## Engineers Comments Regarding Surface Water Drainage

<b>Application Reference:</b>	<b>M/10/26/HH</b>	<b>Reviewer Reference:</b>	ADC/JD/KW/PC
<b>Planning Officer:</b>	Susan Haley	<b>Date of Review:</b>	11/03/2026
<b>Site Name:</b>	5 Shaw Close Middleton-on-sea PO22 7TQ		
<b>Application Description:</b>	Proposed single storey extensions to front and rear, internal alterations, roof extension and loft conversion to semi detached bungalow.		
<b>Assessment Number:</b>	1 of 1

Drawing:  
Proposed Ground Floor Plan

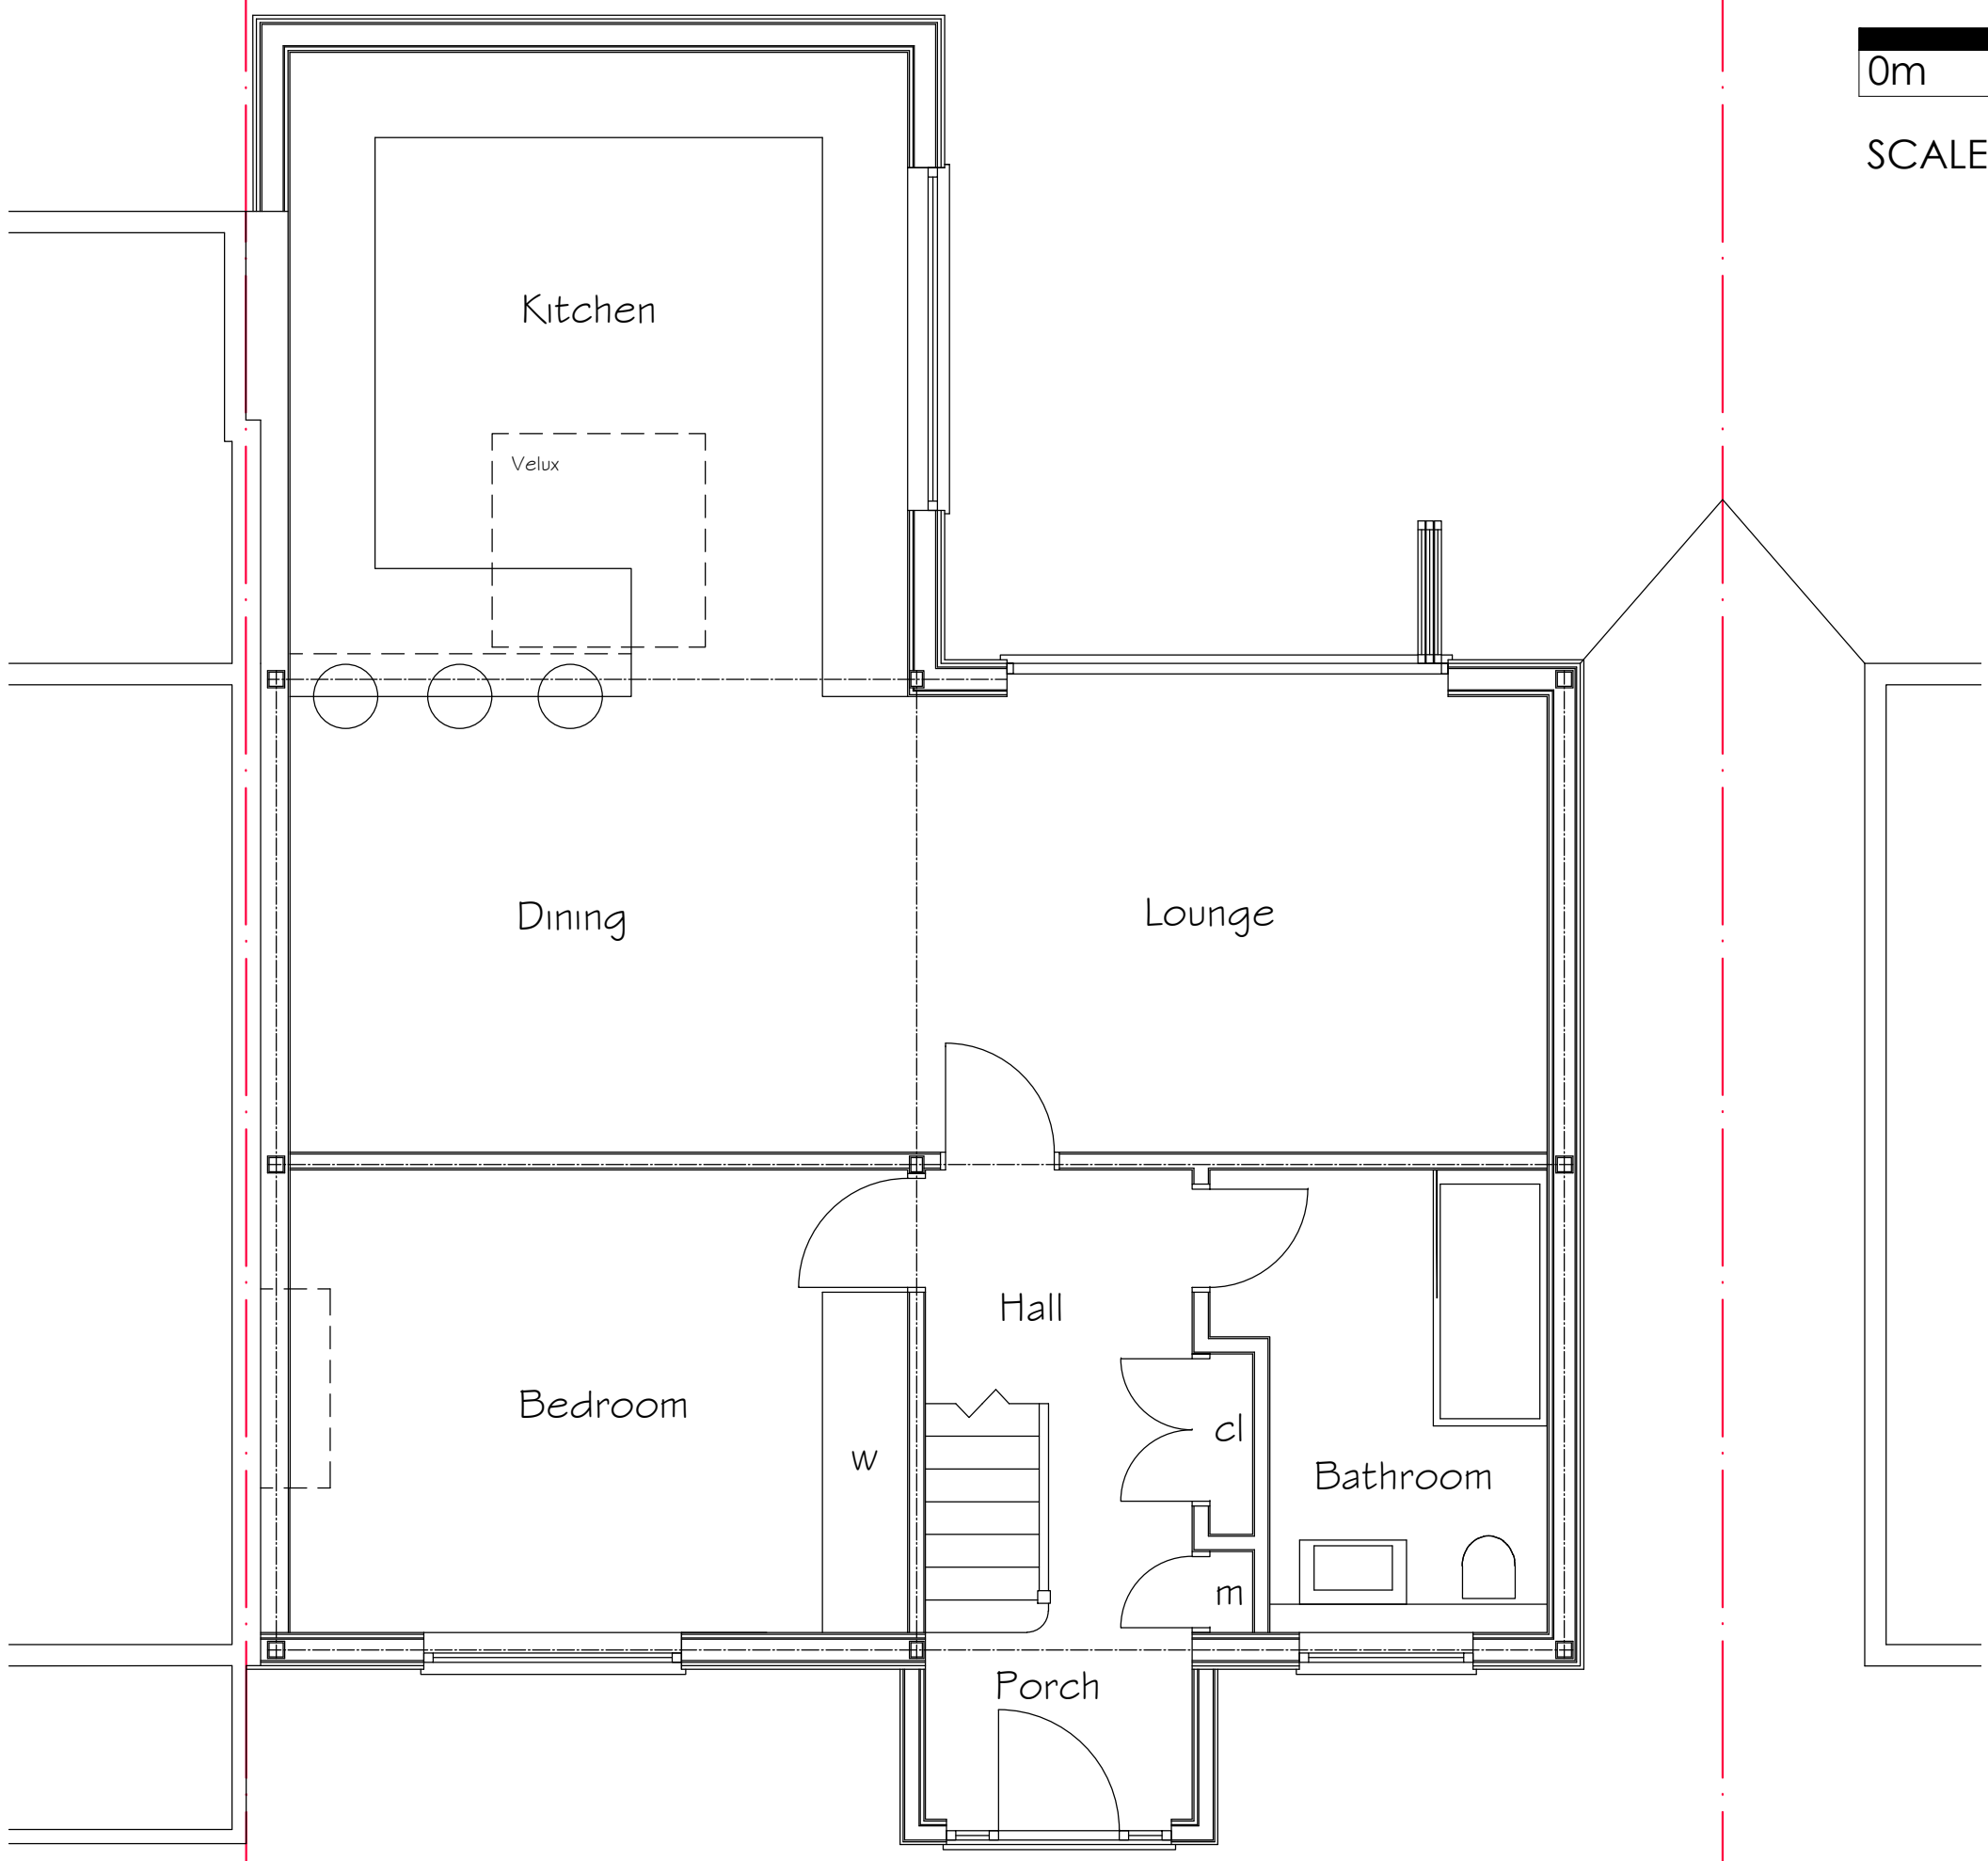
Even where infiltration is viable, space to locate SuDS features are constrained on this site due to the extremely small rear garden to be retained. This is important as the proposed development limits where an infiltration feature can be located. Soakaways must be at least 5m from buildings and highways. The block plan indicates that the building will be approximately 500mm from the boundary at the east, and 5.4m from the boundary at the south; the remaining measurement of the rear garden from the existing dwelling would only be 5.1m in depth. This would leave insufficient space for a soakaway. Indeed, the proposed extensions may disrupt existing soakaways, which have not been assessed for the purposes of this submission. If the existing drainage of the property or neighbouring properties is disrupted and there is no space for an alternative, then flood risk will be increased.
